Subject: Land West of Fontwell Avenue AL/9/21/DOC

We wish to make an objection to AL/9/21/DOC for Planning Permission
AL/122/17/PL

This Construction Management Plan is a Fabrication of the truth. It is not possible in its present form, for the following reasons:

CMP plan

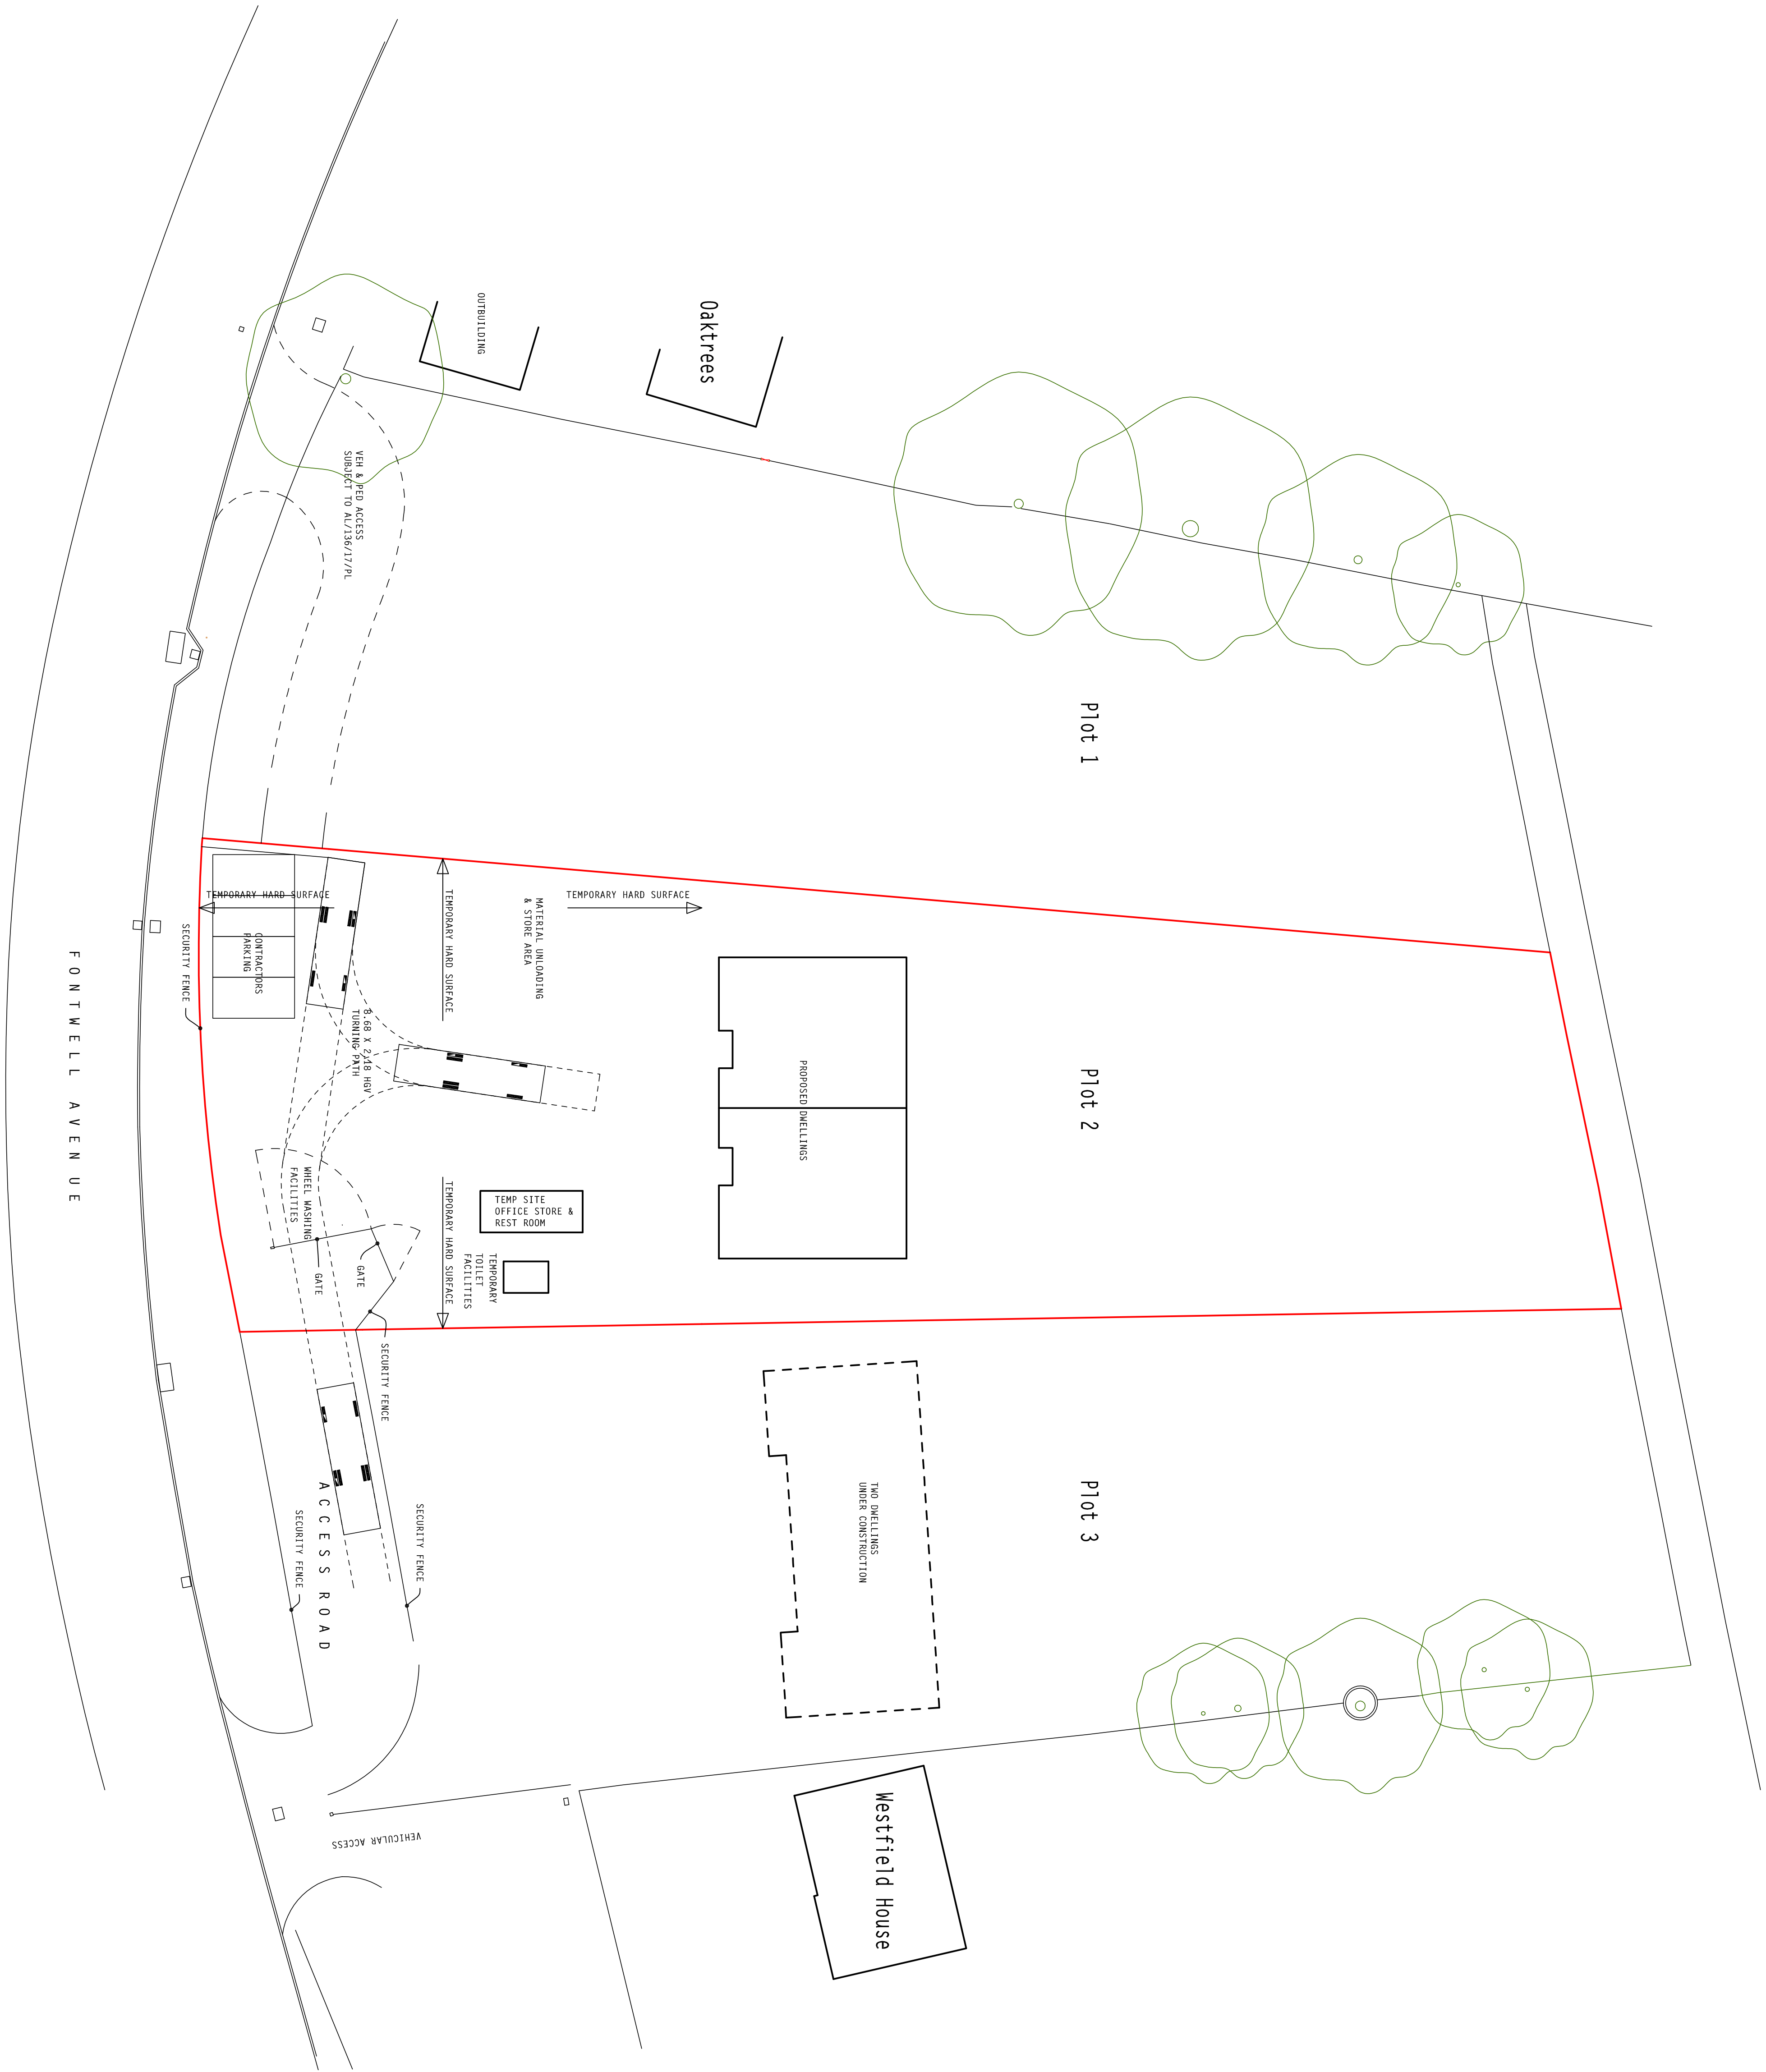
The Heras fencing along the front of the site has already been there for four years and the planning conditions require a maintenance plan for this fencing. There is also no information in this document to shown how the site to the north and south will be made secure. (Presently open to two other sites belonging to two separate individuals and often filled with other vehicles.)
